Date: 8 July 2021
Your Ref: A/26/21/RES
Our Ref: 12491D

**APPLICATION FOR THE APPROVAL OF RESERVED MATTERS (APPLICATION REFERENCE A/26/21/RES)
AT LAND SOUTH WEST OF BROOK LANE AND SOUTH OF A259, RUSTINGTON**

Following our previous correspondence dated 26th May 2021, this letter has been prepared and submitted alongside updated plans which respond to comments received from yourself, West Sussex County Council Highways, West Sussex County Council Public Right of Way officer and Arun District Council Greenspace officer

Drawing title
Plots 38-39 - Elevations
Type: P-3H-7

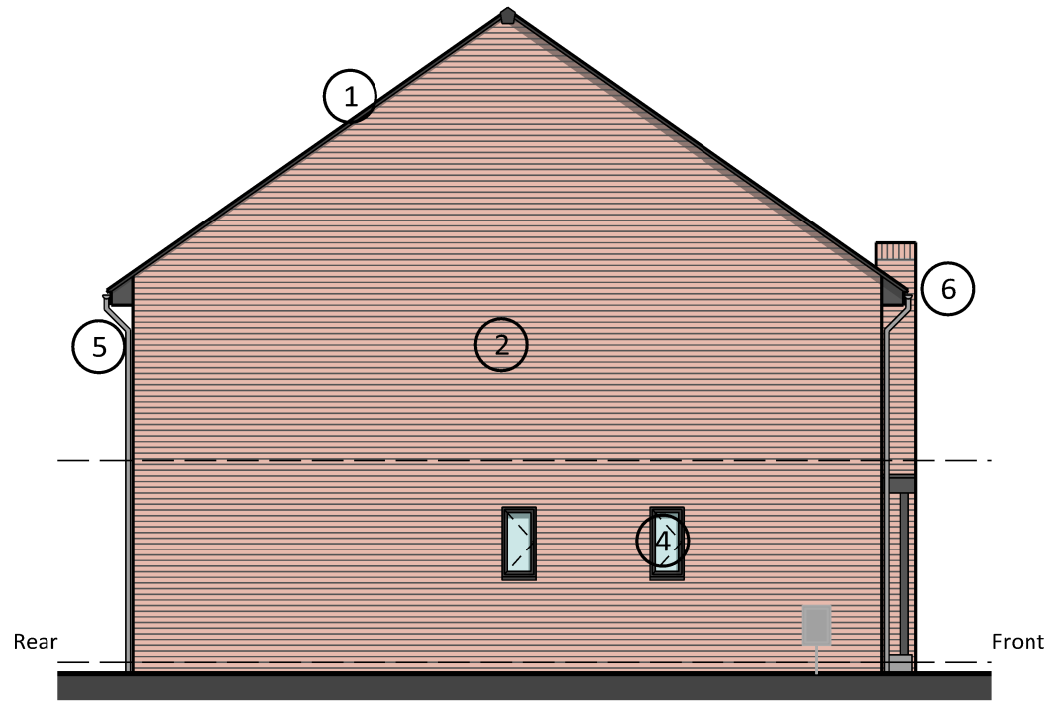
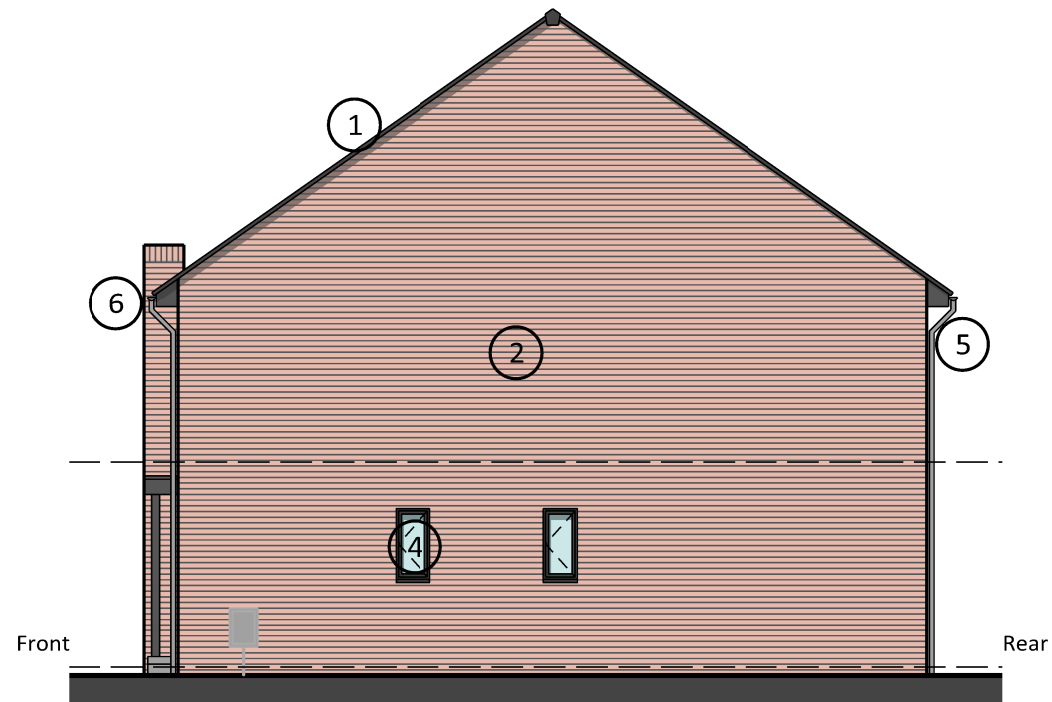
"I have taken the opportunity to discuss the layout with other officers and would appreciate further thought being given to the potential for the units to the north of the LAP open space plots 38-43 to front onto the area, rather than rear/side elevations. Would it possible to combine this LAP area with that to the east to allow some adjustment to plot orientation or to alter the position of some of the units to the west of these units?"

The layouts and orientations of residential dwelling Plots 38-43, situated to the south of the central LAP have been amended so the dwellings front onto the LAP to afford an element of natural surveillance. Please refer to the following plans submitted for further information:

176-202 P3

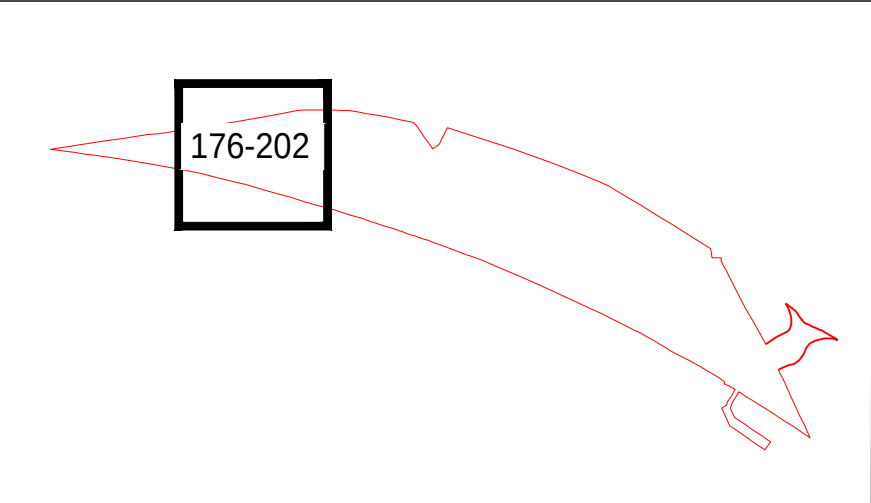
The design team has considered the consultation response provided by the LPA's Greenspace officer. In respect of comments received on the planting schedule and quantities of planting, the revised landscaping information submitted (drawing no. 176-SCH-001_P3) to confirm the actual plant quantities. Furthermore, the associated Planting Plans detail the proposed planting mix in the locations of soft landscaping proposed (drawing nos. 176-201_P3, 176-202_P3, 176-203_P3, 176-204_P3, 176-205_P3 and 176-206_P3).
